Reference : Objection to Planning Application BE/151/11 Shripney Garden Caravan Site

Extension to existing caravan park to provide 12no. additional mobile homes, associated parking area, formation of access and construction of electrical intake housing -
Amendment to application BE/42/10

Land South of Shripney Garden Caravan Park, Shripney Lane Bognor Regis

SHRIPNEY GARDEN CARAVAN PARK, SHRIPNEY LANE, SHRIPNEY
Proposals 01
Nov 2011

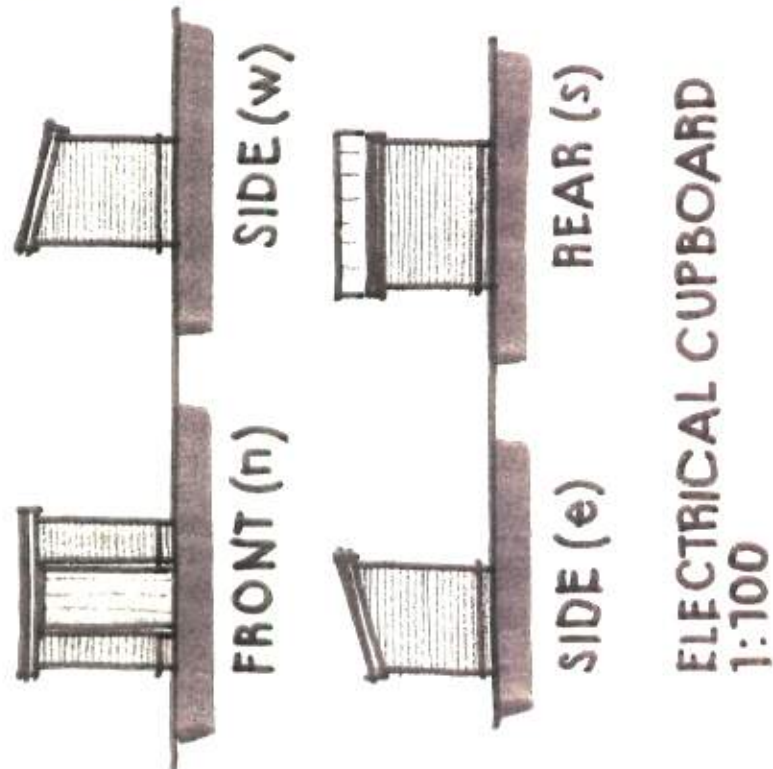
The proposed new access has virtually no visibility to the north and would constitute a hazard. Seriously detrimental to the amenity of long existing residents as mobile homes have been placed much closer to them than on the approved plan. Visual amenity of what was a pleasant aspect becomes an eyesore, particularly now that the old flint wall has been demolished, which was not shown on the original drawing. Also, the construction of an unsuitable electrical intake building has been placed too near residents home. This would also constitute an over development of the site as it is, without further additions. We strongly feel the original permission of BE/42/10 should not have been granted for the many valid reasons that were stated in the past when a previous application was refused on appeal.
